# CITY OF PORTLAND BUILDING PERMIT

Located At 178 MIDDLE ST

Job ID: 2012-07-4419-ALTCOMM

has permission to Renovate interior office on 5th Floor

SECOND FLOOR PLAN  
SCALE 3/16" = 1'-0"

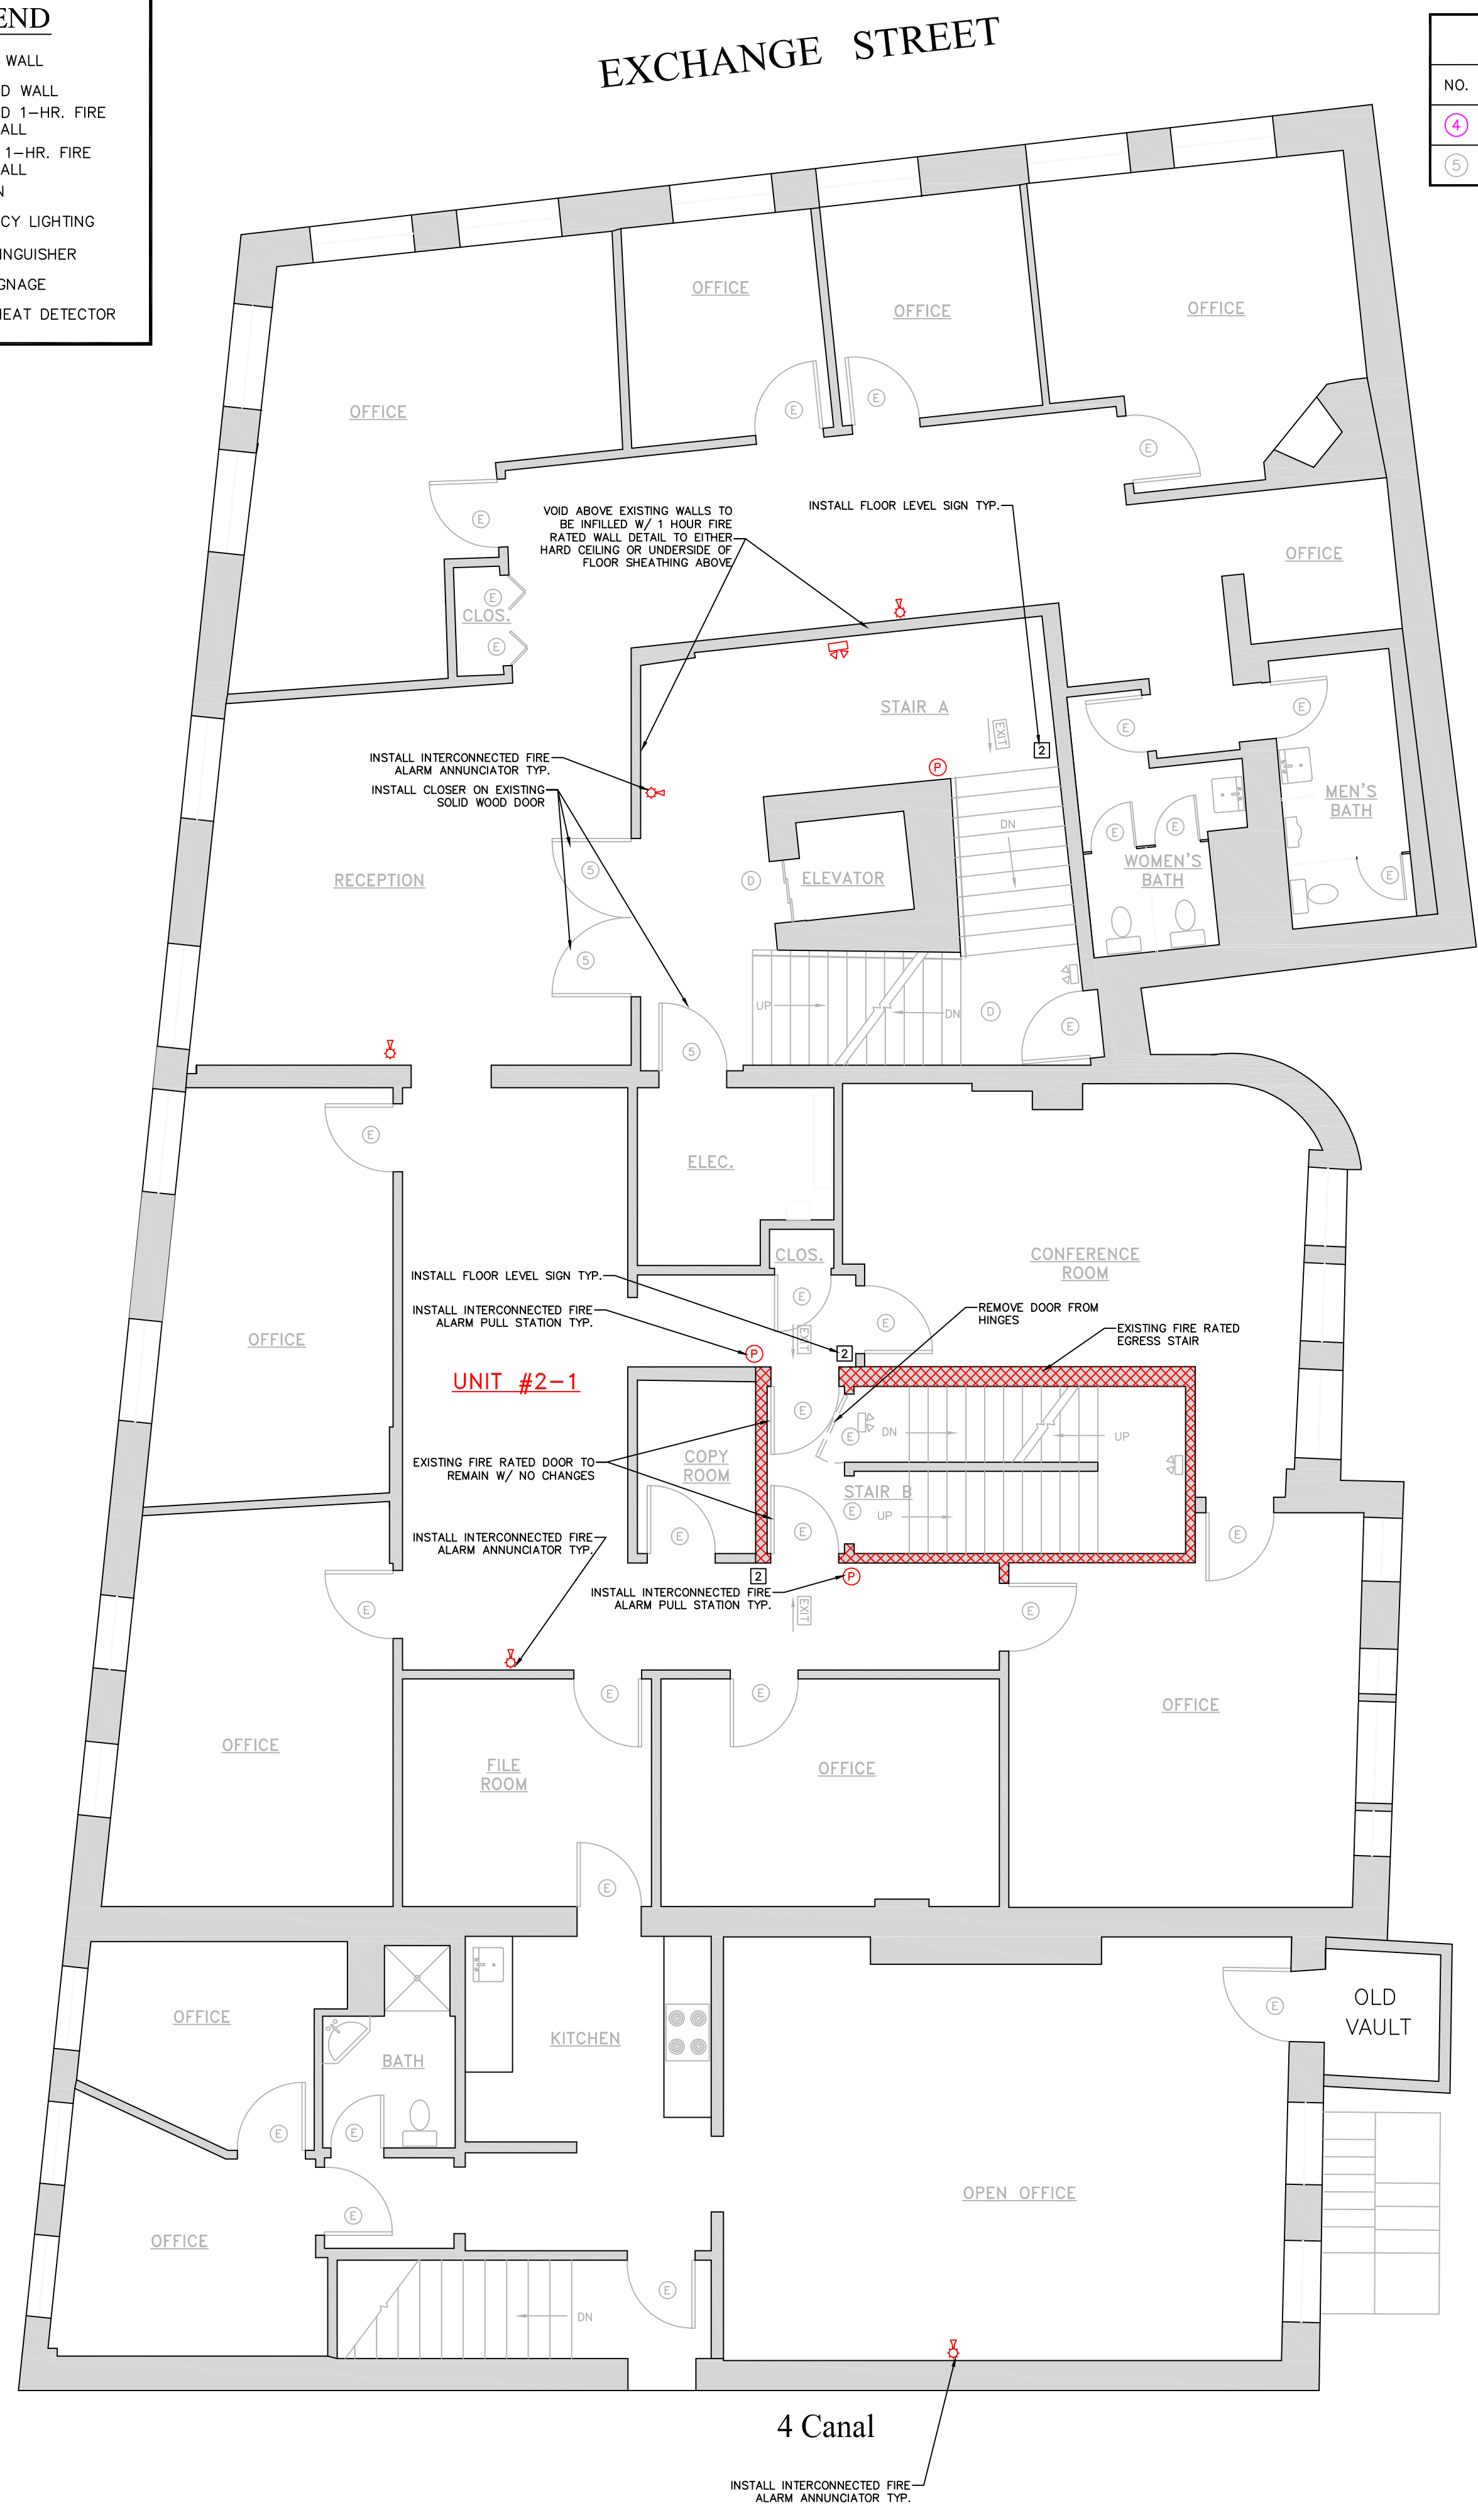
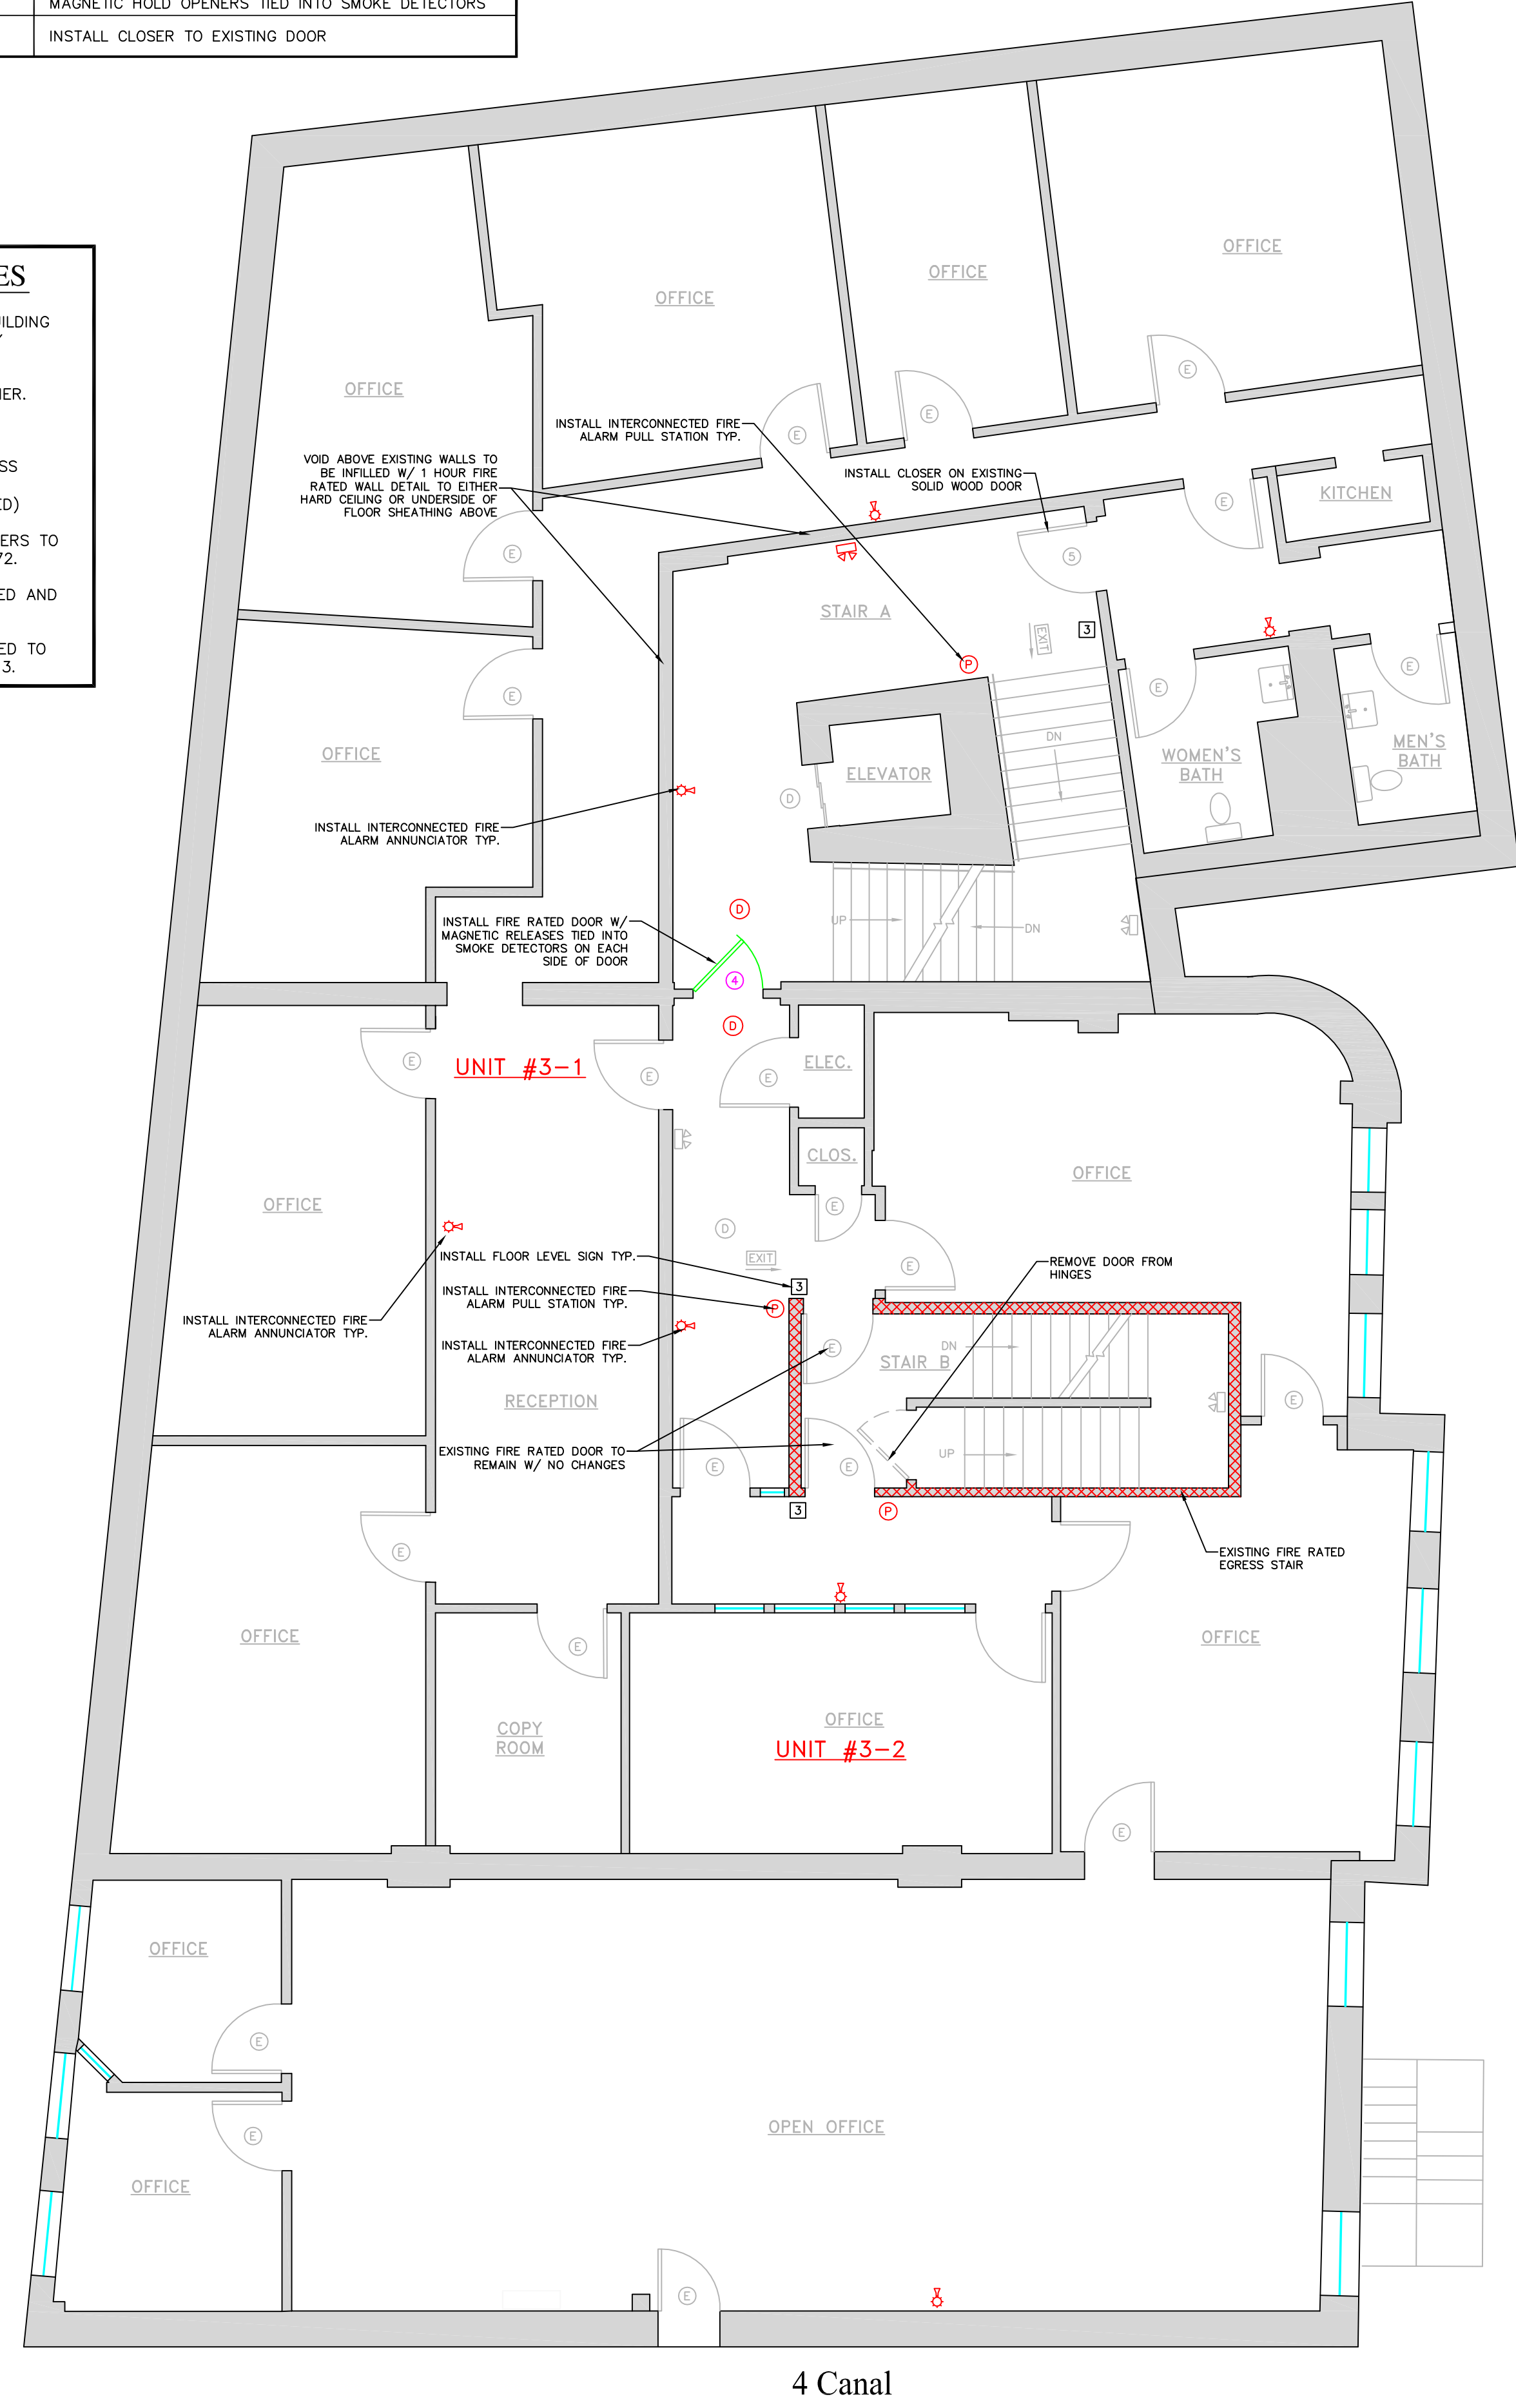
1. The stair identification signage shall be located within the stair enclosure at each floor landing and visible when the door is in the open or closed position.

2. The door from Unit 4-2 directly into stair A needs to swing into the stair enclosure. As you approach to leave the hinges should be on the left and the lever on the right.

3. You may want to post signs on the doors into Stair B that state "EMERGENCY EXIT ONLY" since the doors don't provide re-entry onto the floor once you enter and the stair discharges into the back alley.

4. All door assemblies into the exits must be 1-hour fire rated. Existing doors will require inspection by a certified or approved door inspector. Chuck Noble is the only one I know of around here but there may be others. His number is 490-2500.
